Our Ref 600283-L002

13 December 2011

RE: MEADOWBANK PRECINCT MASTER PLAN, SHEPHERDS BAY

Please find attached updated stormwater drainage concept drawings as requested.

Drawing Title : UPPER BASEMENT PLAN

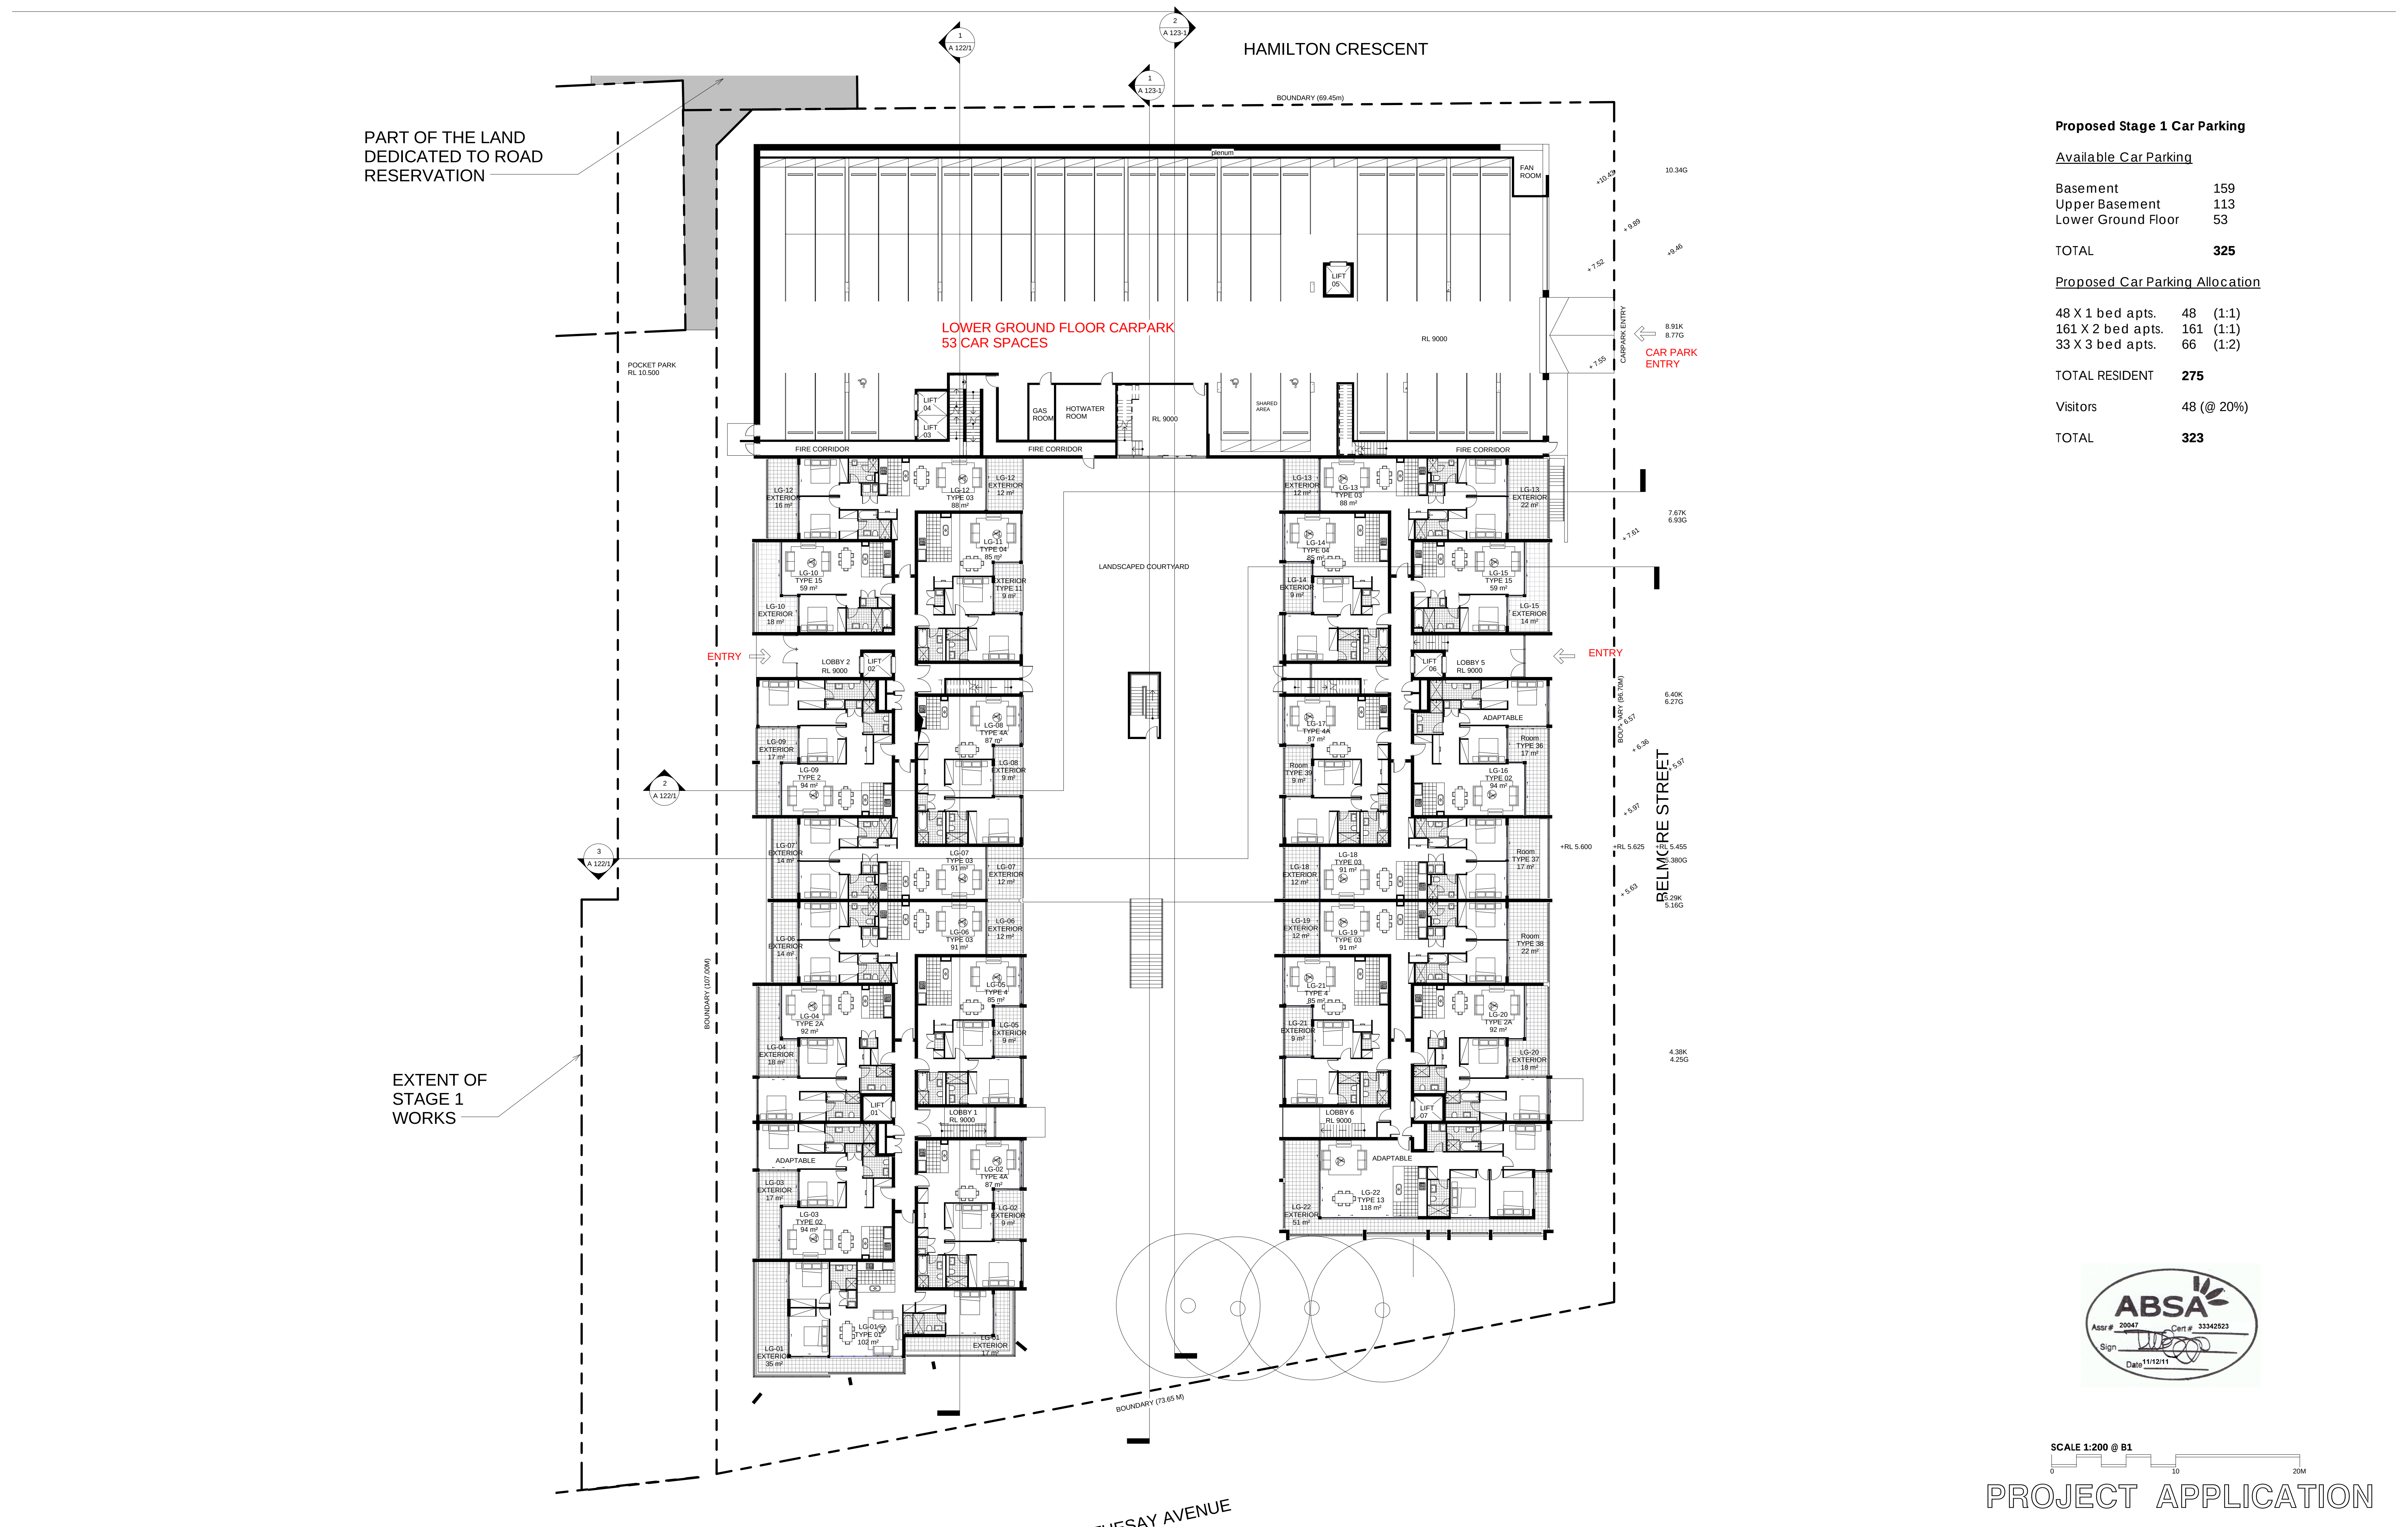
We confirm that the latest architectural layout changes have minimal impact on the overall site stormwater strategy. We note that the location of the rainwater tank shown under the upper basement vehicle ramp has been relocated to suit the amended location of the ramp.
